ADDENDUM

Project: Science Building Research Wing Expansion

Project No. 03049

Addendum: No. 1

SECOND FLOOR & PENTHOUSE PLANS

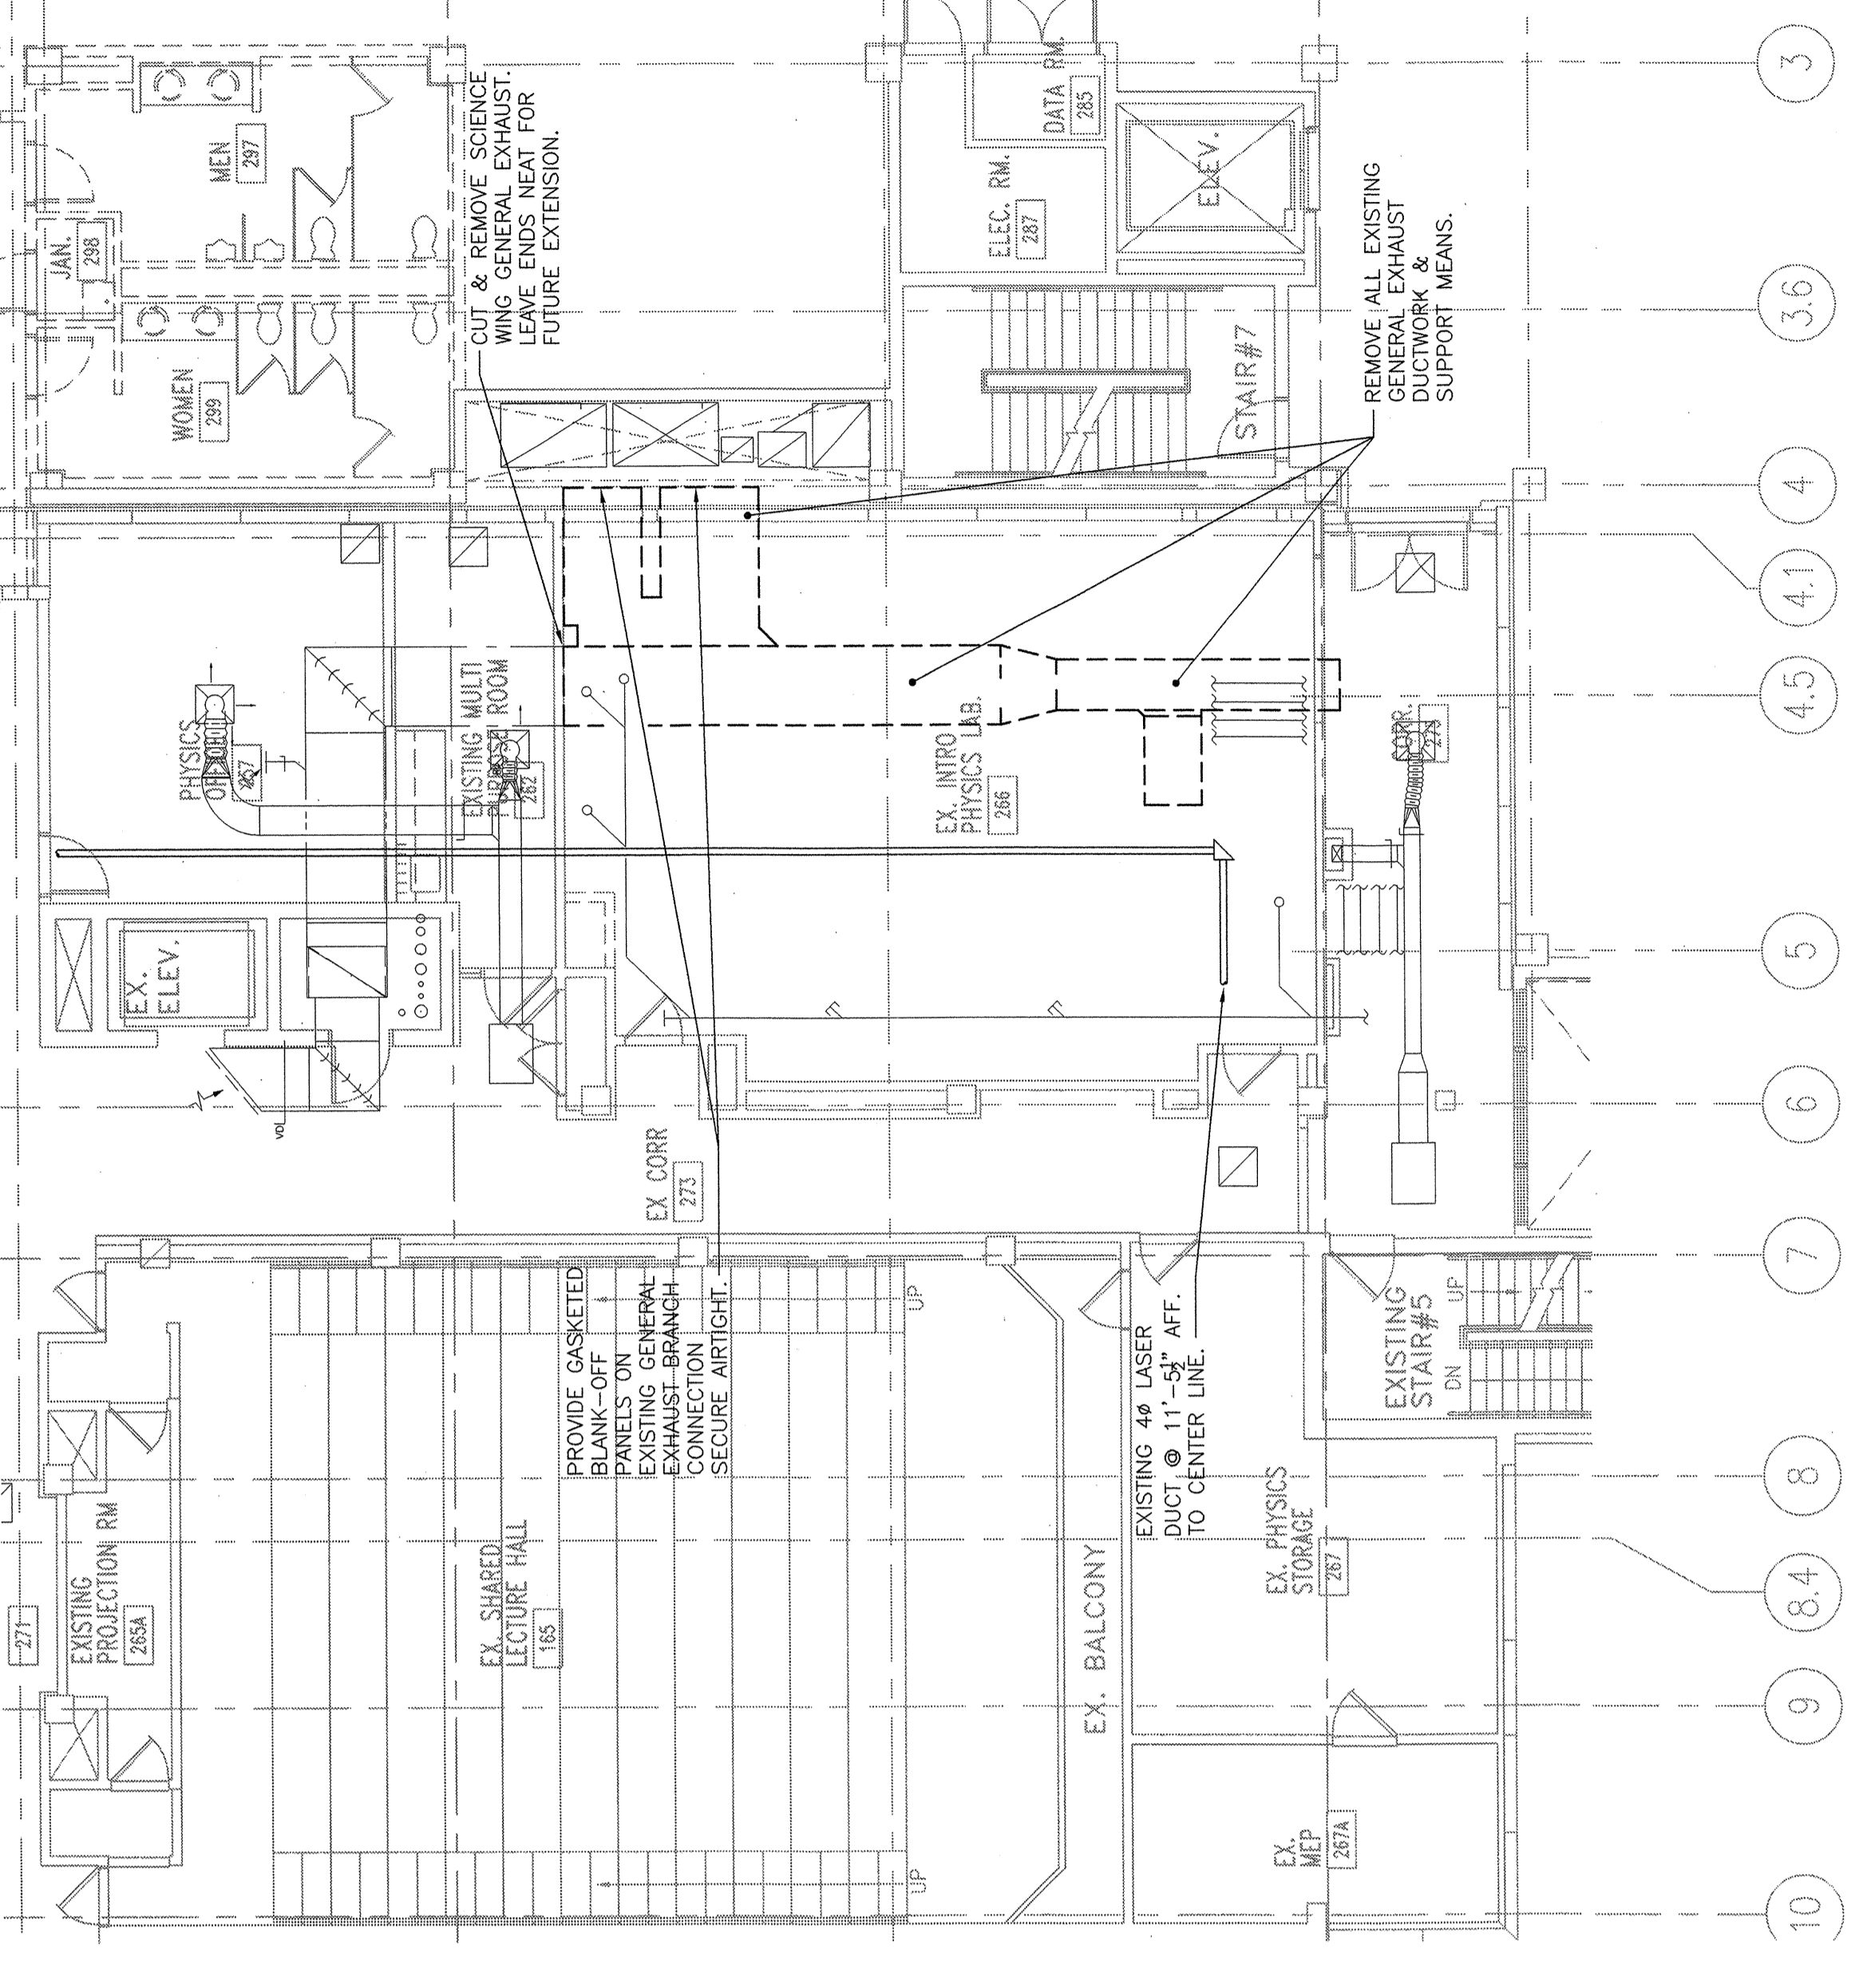
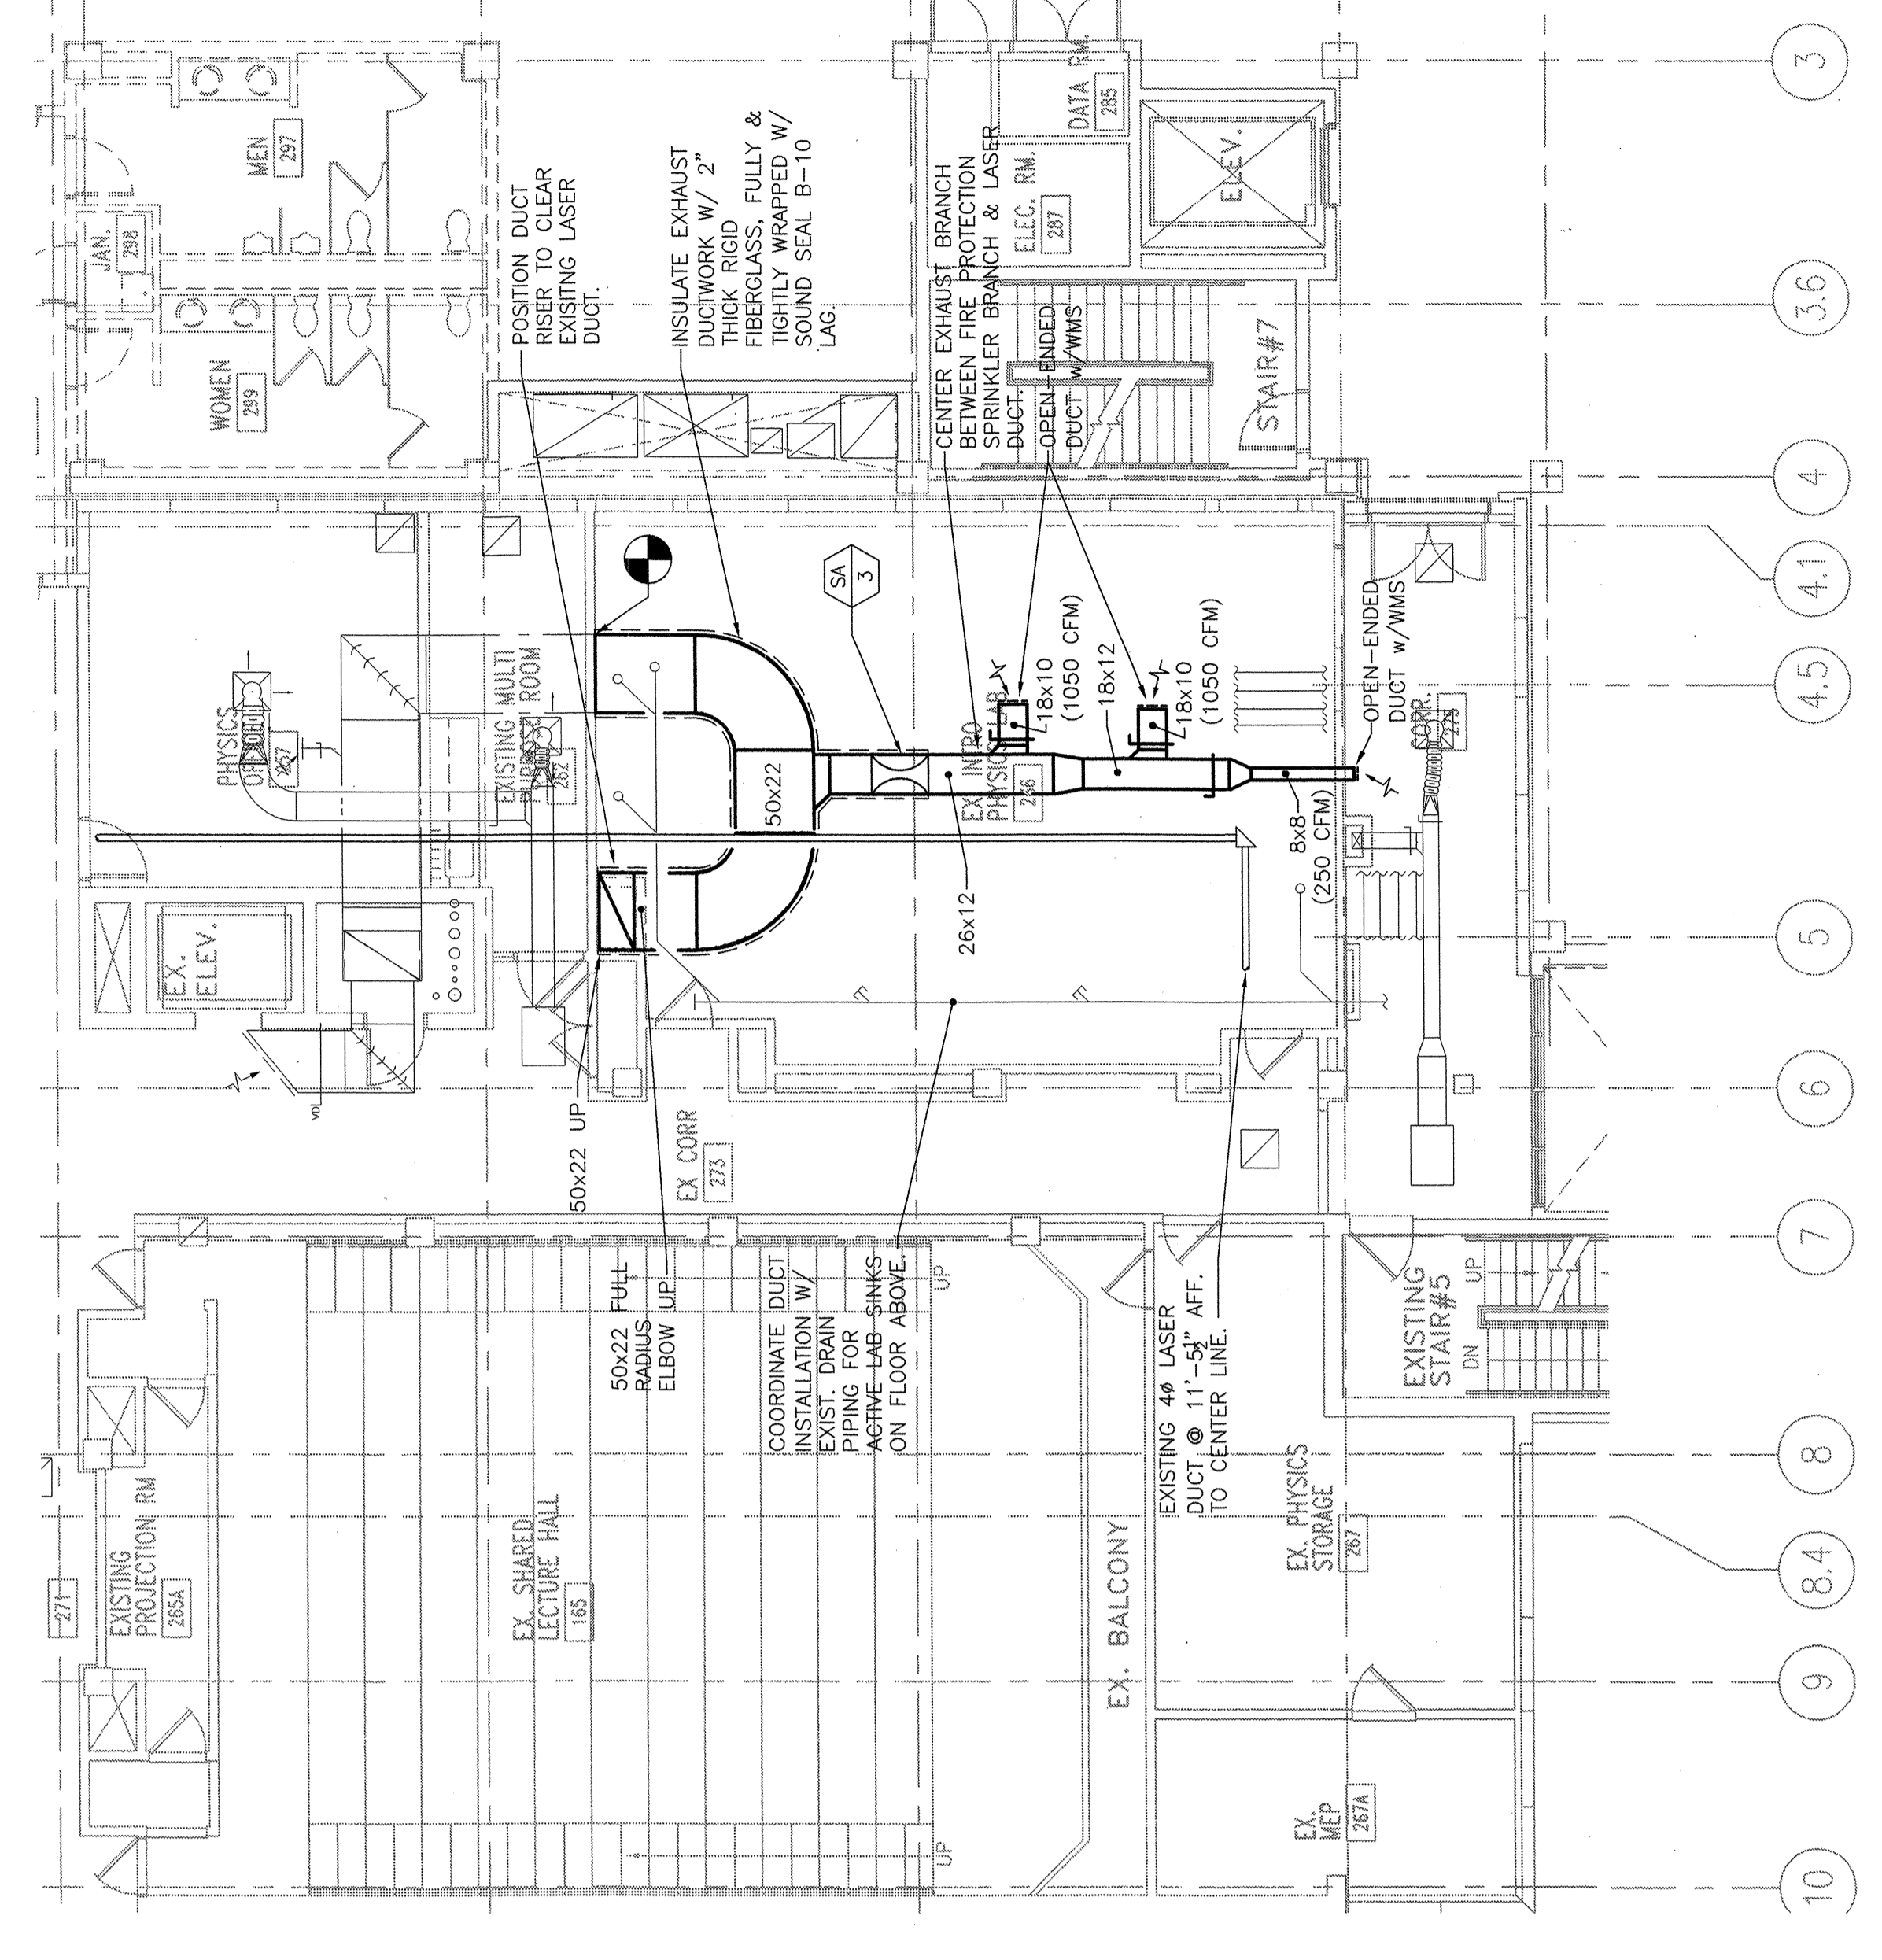
M2.1 Second Floor and Penthouse Plans

1. Change note at EF/22 to read "Extend 4" ERS7R across roof I connect to coil in EF-22-ERU. Provide shut-off and balance valves."
